MEMORANDUM

FILE REF ACS Hillingdon International School, 108 Vine Lane, Hillingdon UB10 0BE

RESPONSE TO LB HILLINGDON CONSULTEEES

CLIENT	
ACS International Schools	
PROJECT	
ACS Hillingdon - Sports Hall Extension	
DRAWING TITLE	
Proposed Multi-use Hall Roof Plan	
SCALE @ A3: As indicated

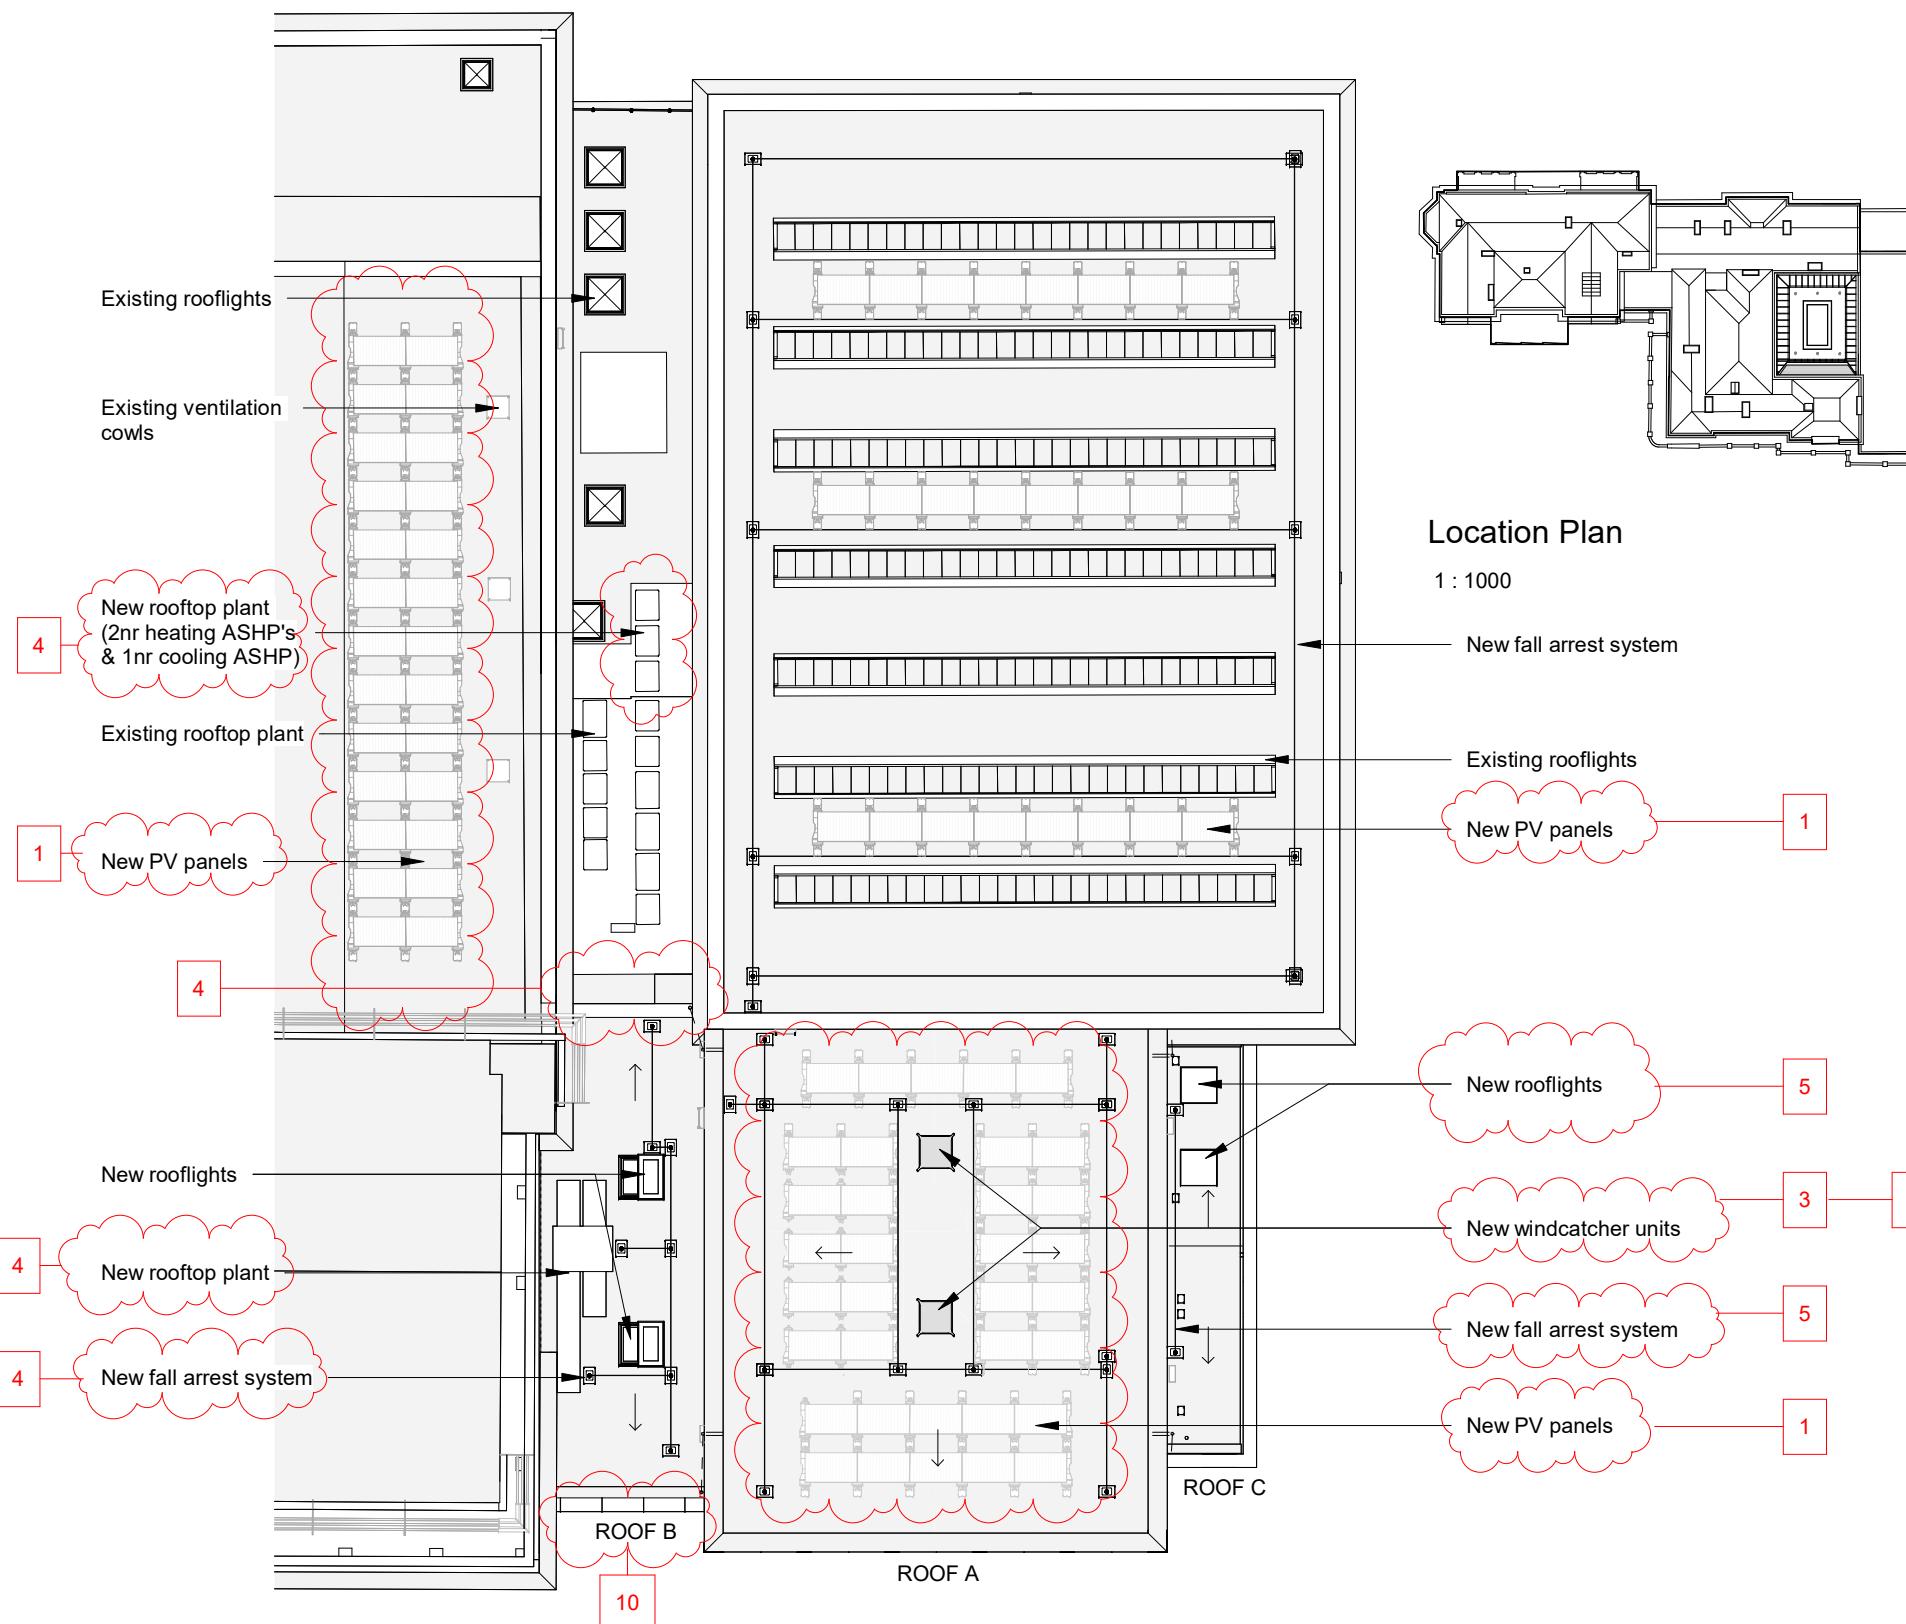
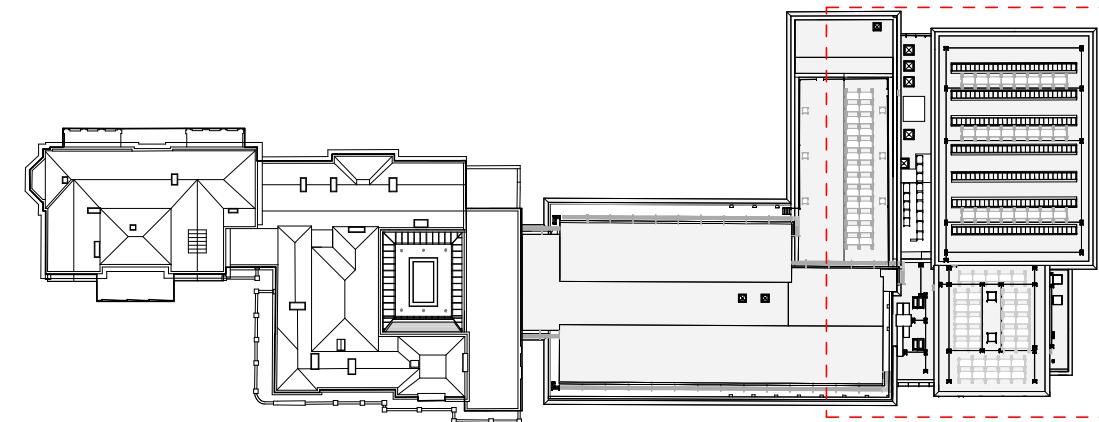
5	The profile of the additional roof lights needs to be supplied with a section at 1:50 to include the New Fall arrest system. It needs to be fully demonstrated that these elements will not create a visual impact.	Two additional views have been provided which show the fall arrest system and roof lights (red dashed lines). These confirm the 4x additional roof lights are low level and do not create a visual impact when viewed from ground level.	1689-ID-PL-XX-DR-A-3006-P01 - Proposed North View 01 Rooflights 1689-ID-PL-XX-DR-A-3007-P01 - Proposed North West View 01 Rooflights
	6	The provision of two pairs of external doors is accepted.	Agreed	N/A

CLIENT	ACS International Schools
PROJECT	
PROJECT	ACS Hillingdon - Sports Hall Extension
DRAWING TITLE	
Proposed Multi-use Hall North & West Elevations	
SCALE @ A3: 1 : 200

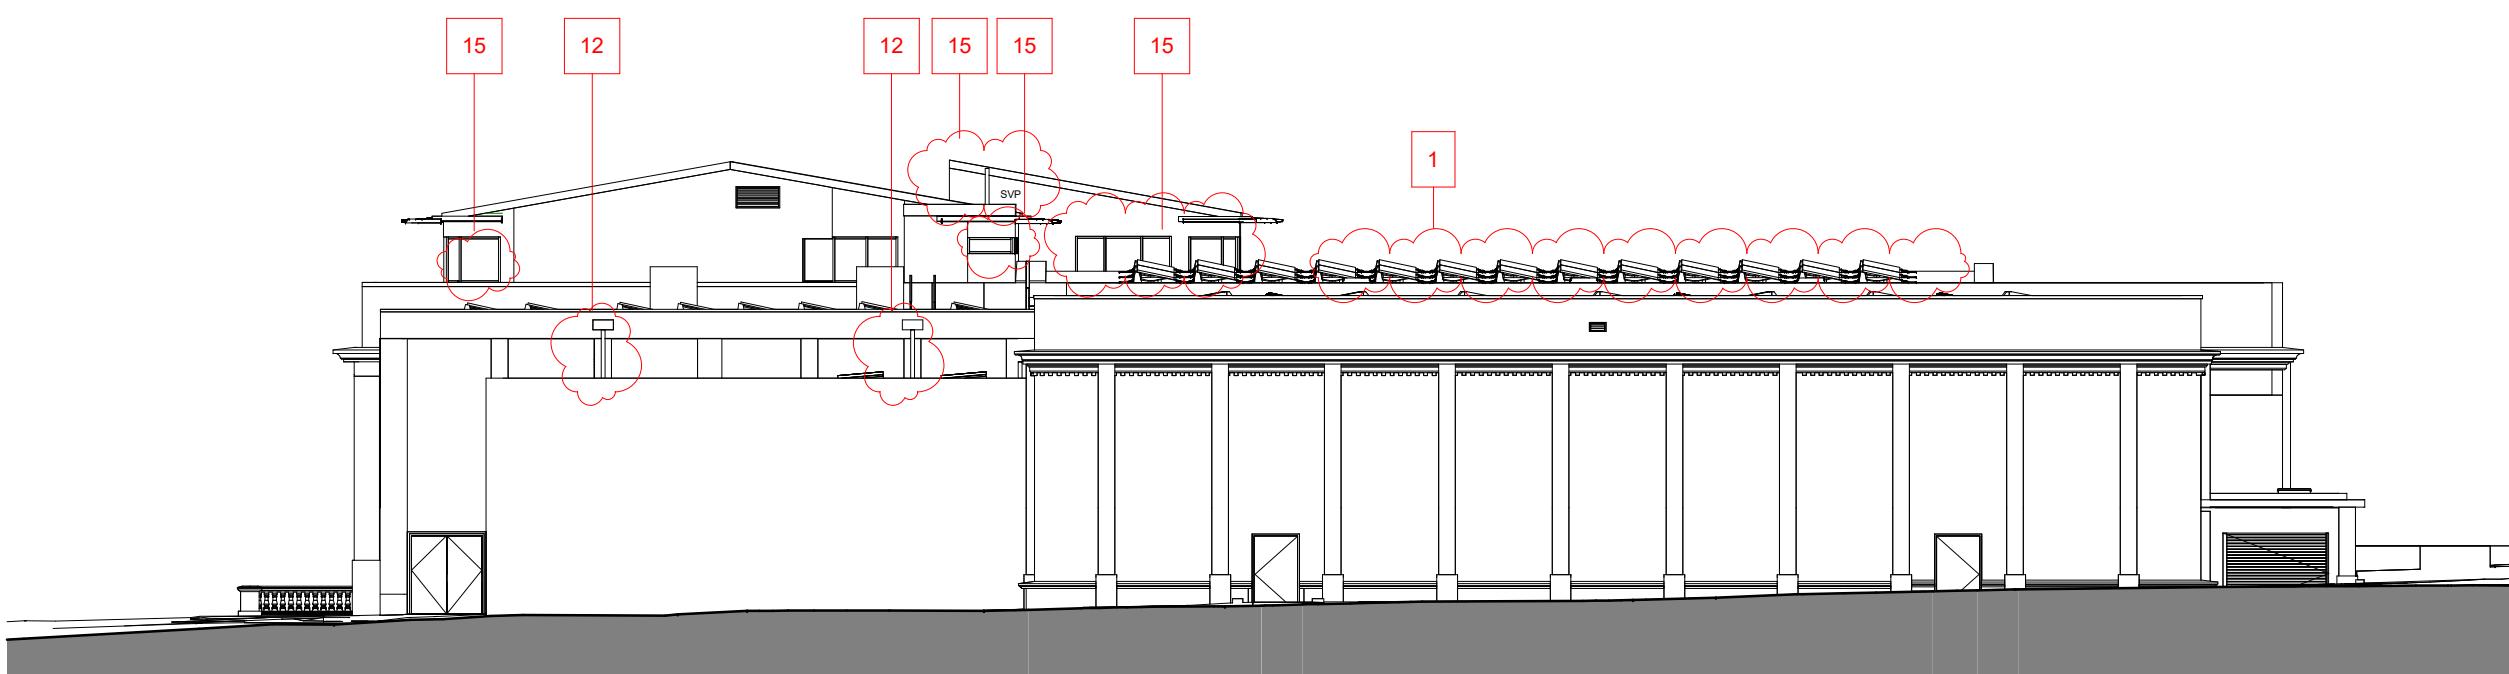
7	The proposed doors approved on the elevational drawings are accepted.	Agreed	N/A	
	8	The introduction of a 525mm high facing brickwork cill to these glazed elements is accepted subject to further information on the materiality of the cill.	The cill facing material will be a pale brick Bespoke Brick Company 'White Smooth' to colour match the 'Ivory Limestone' Haddonstone columns. This brick will also be used for the two-storey wing to the west elevation.	N/A	
	9	Further information is required comparing the dimensions of the approved elevational drawings and the proposed dimension of the plinth, piers widths, wide corners and high parapet. The depth of the reveals should also be included comparing the approved drawings with the proposed	Various additional plans have been supplied with information regarding the measurements requested. As discussed within the submitted documents, the approved drawings had various inconsistencies. This application seeks to have a uniform set of drawings with correct dimensions throughout. The only height listed on the previous consent was 7910mm on Proposed Section PrD-A-04-100 PD4, which is overlaid on 3060 Section 2 to compare to the current proposal.	1689-ID-PL-XX-DR-A-2060-P02 - Proposed Multi-use Hall North & West Elevations 1689-ID-PL-XX-DR-A-3060-P02 - Proposed Multi-use Hall Sections 1 and 2
